## **PLANNING REFERENCE 21/02913/FUL**

### **LAND AT DUCK END FARM, PARK LANE, DRY DRAYTON, CB23 8DB**

Please find attached to this letter a Non-material amendment (S96A) application which follows the grant of planning permission 21/02913/FUL in December 2021.

Elevations - Barn - Proposed

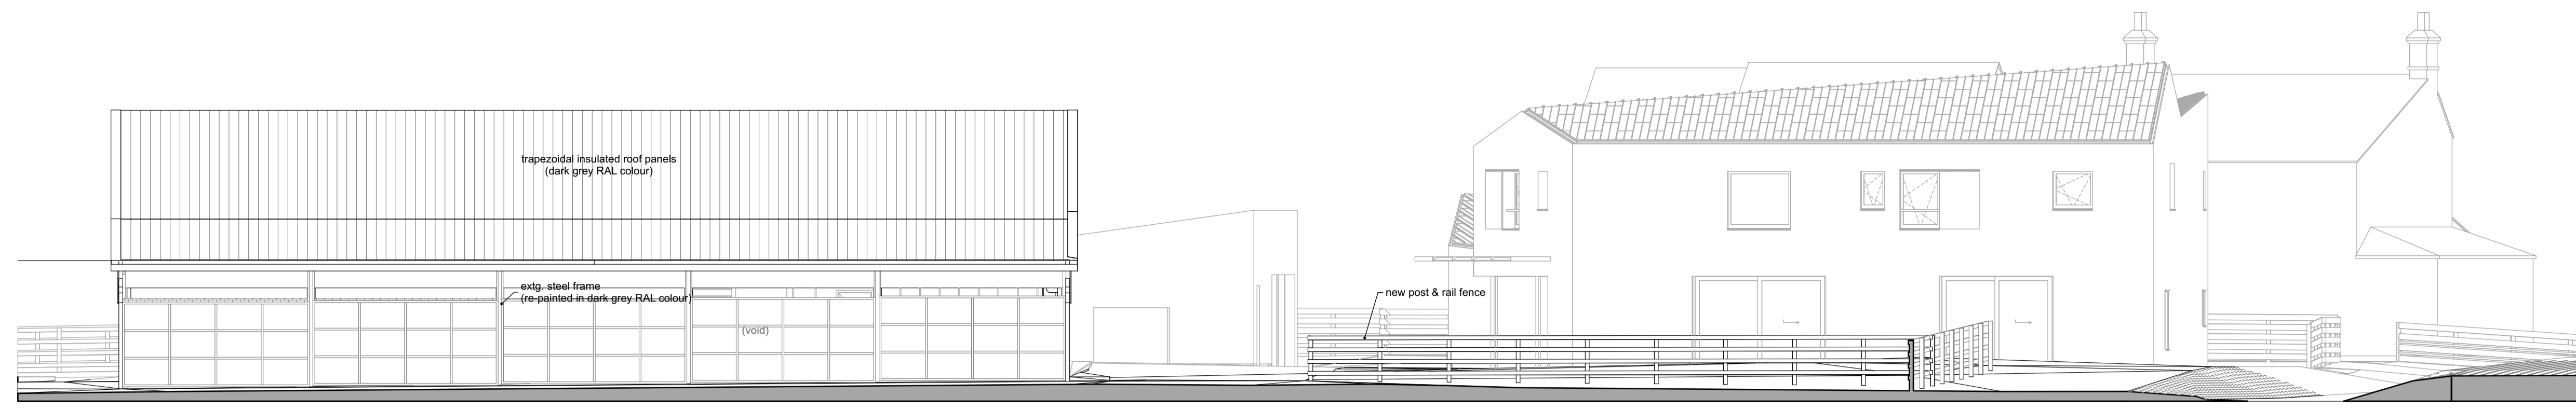
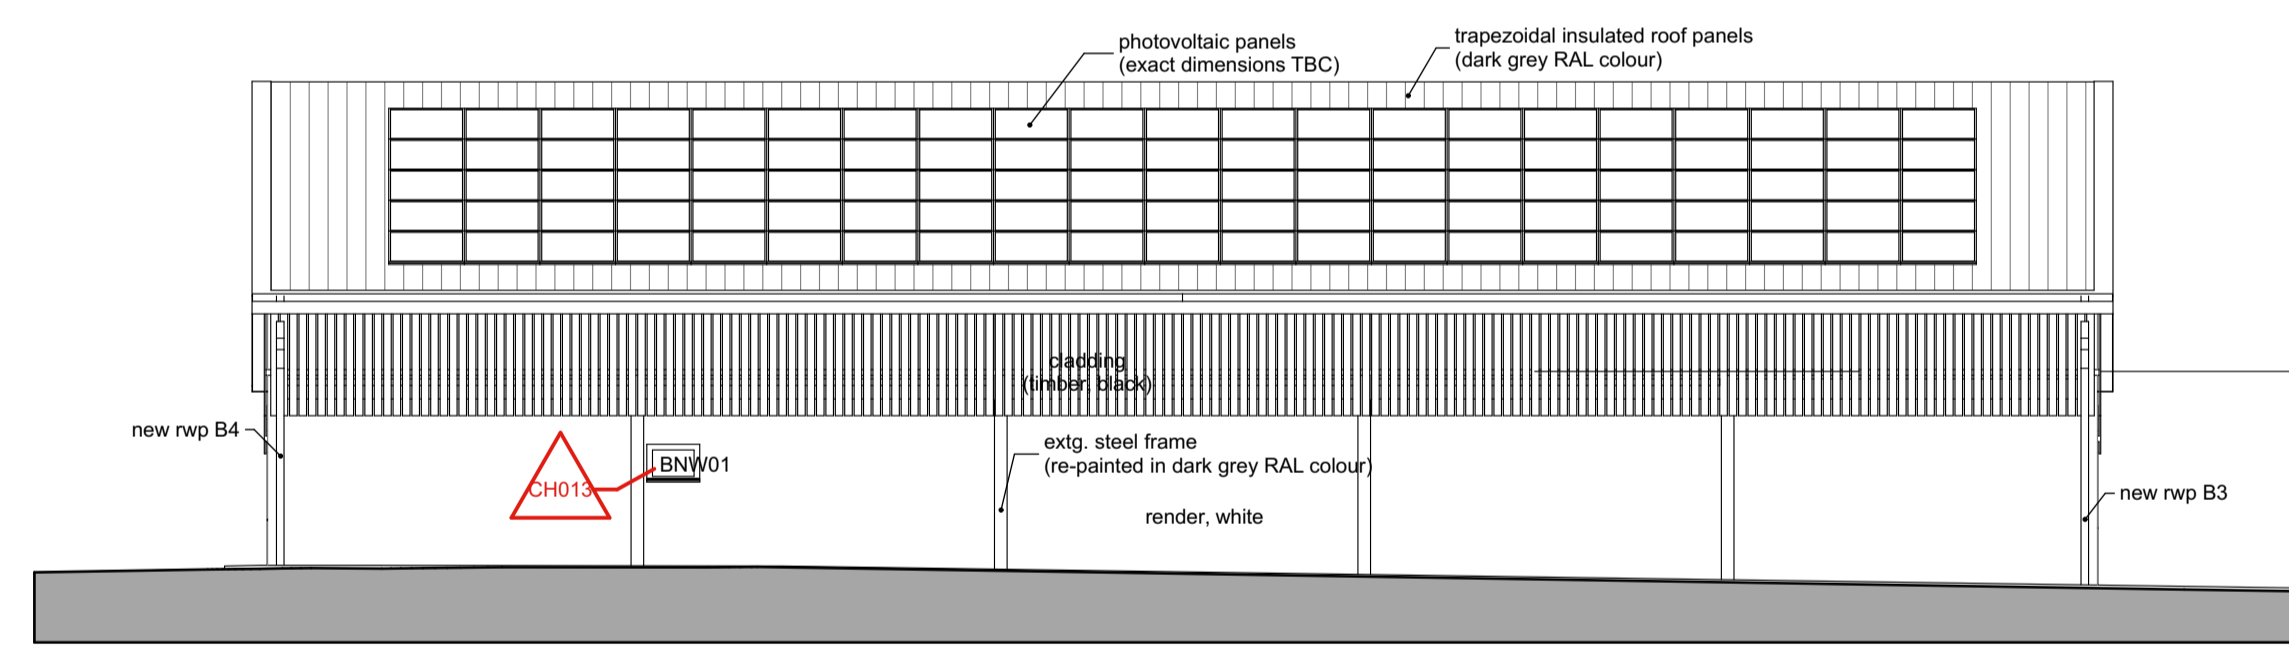
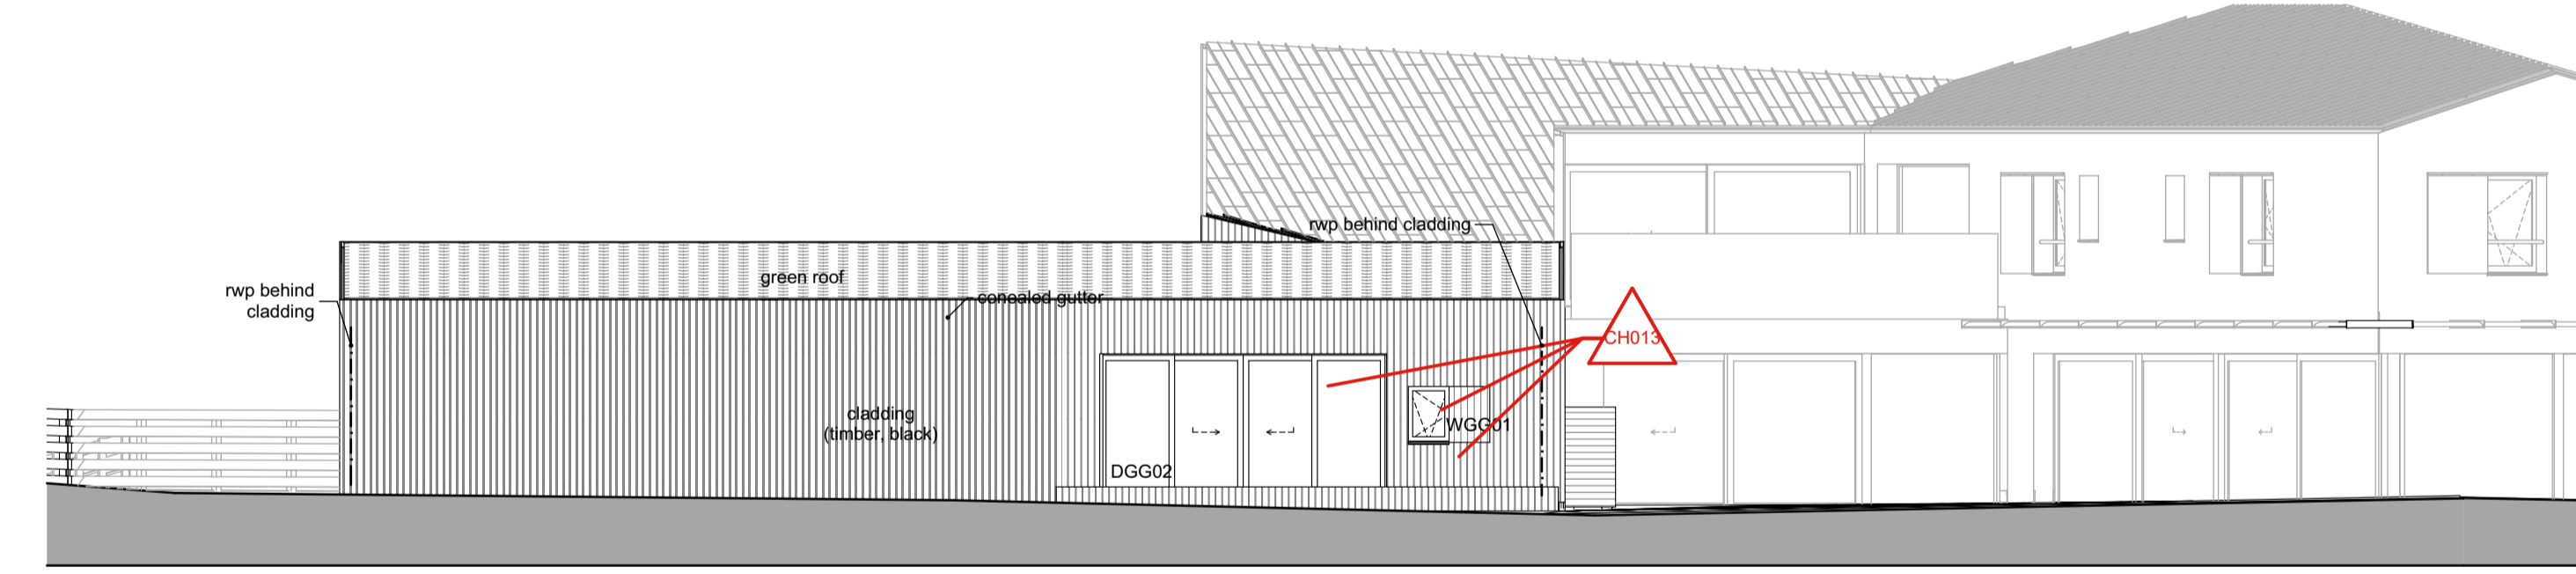
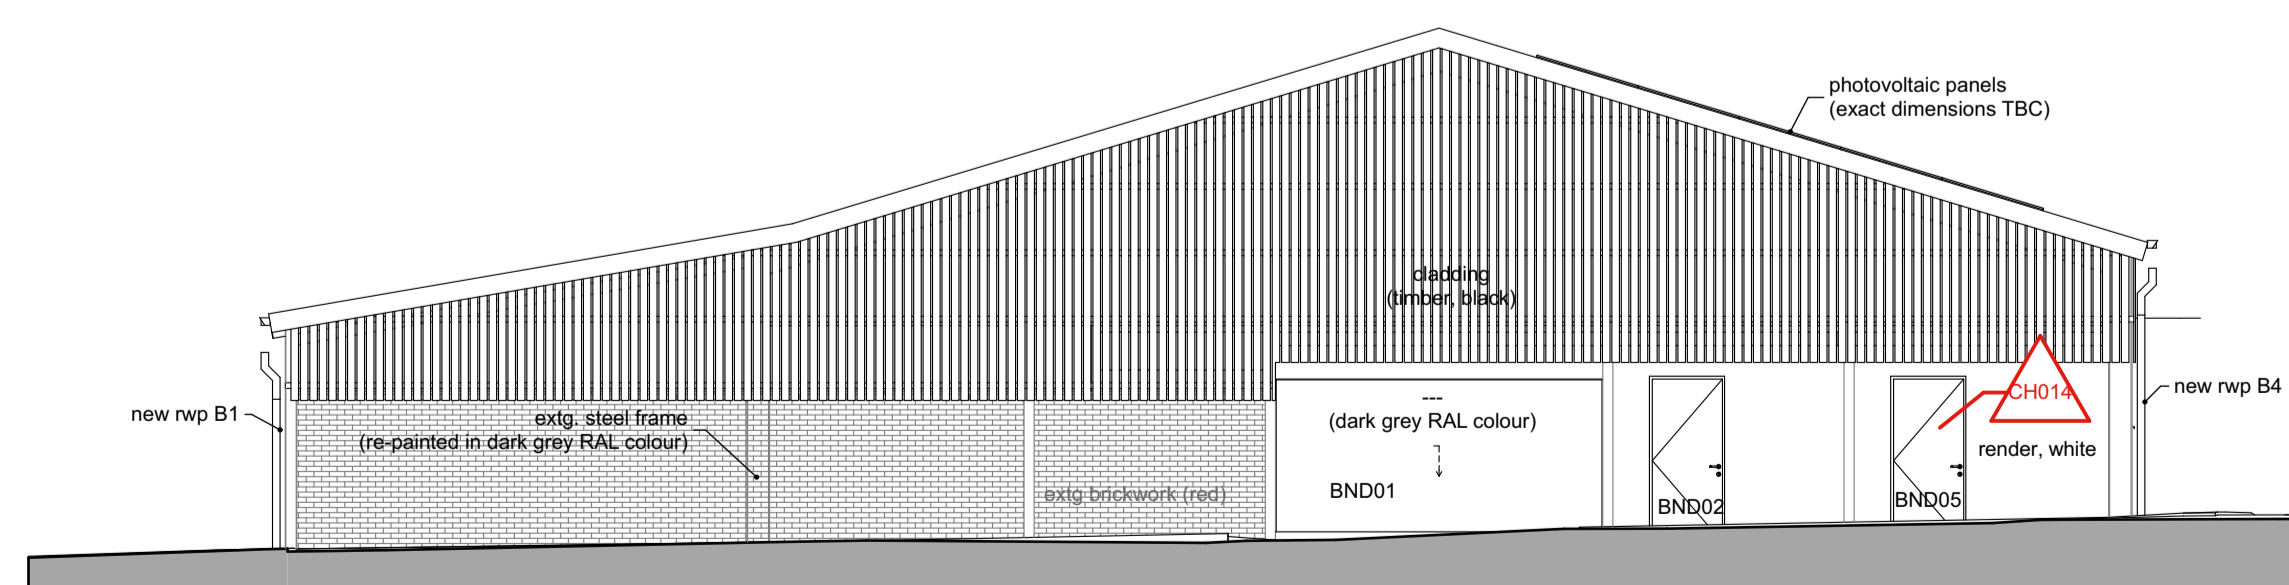
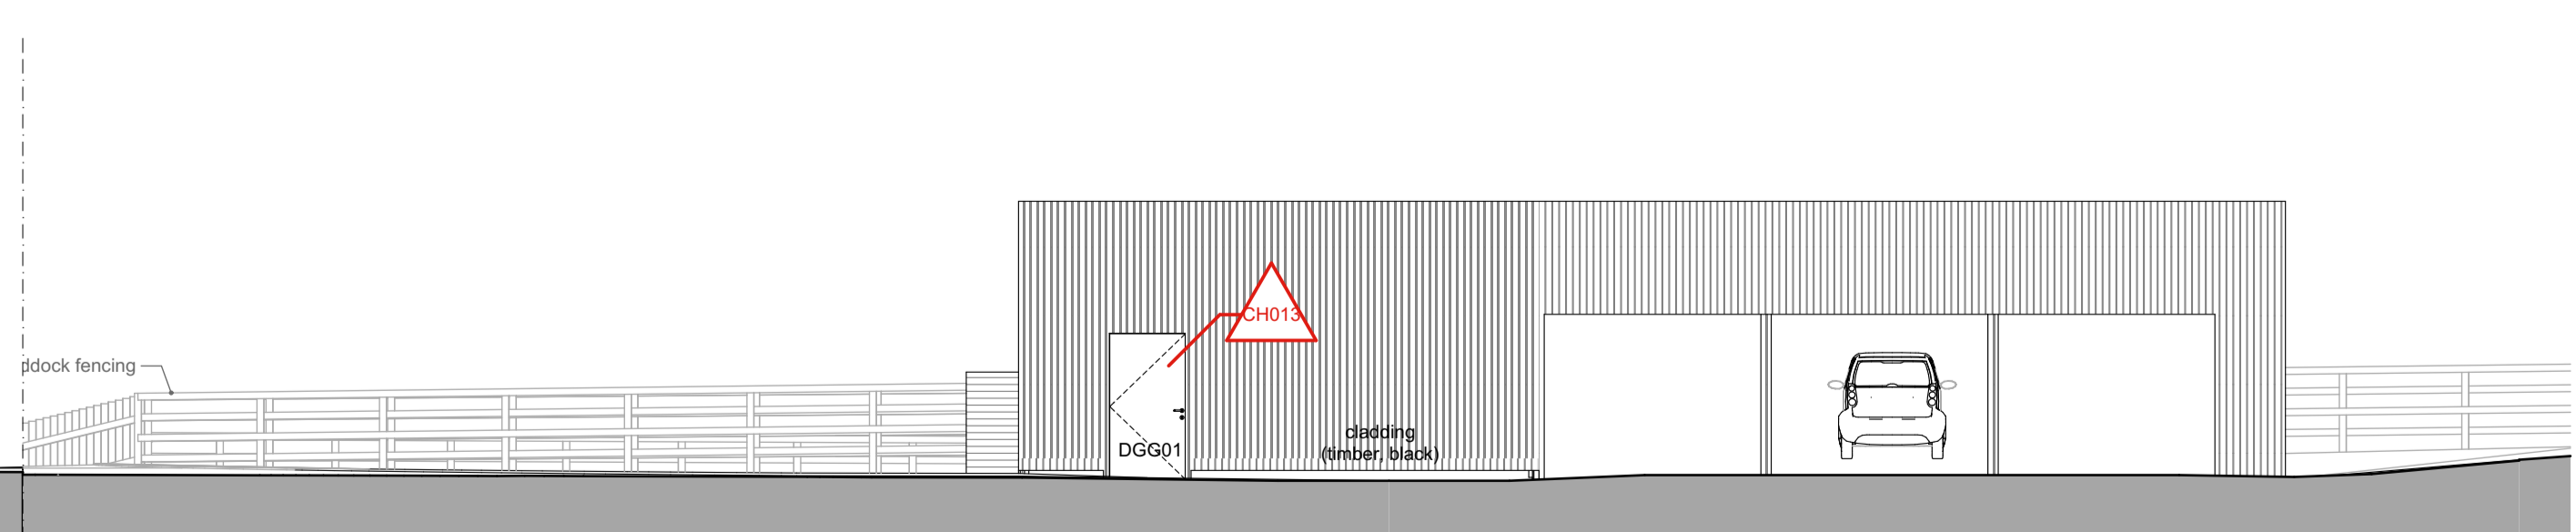
- Change in finish of the roof from timber cladding to a standing seam zinc, coloured in dark grey. This will match the proposed cladding.
- Addition of a door to the barn for plant room access.
- Window size/ lateral position adjustments to fit selected cladding system.
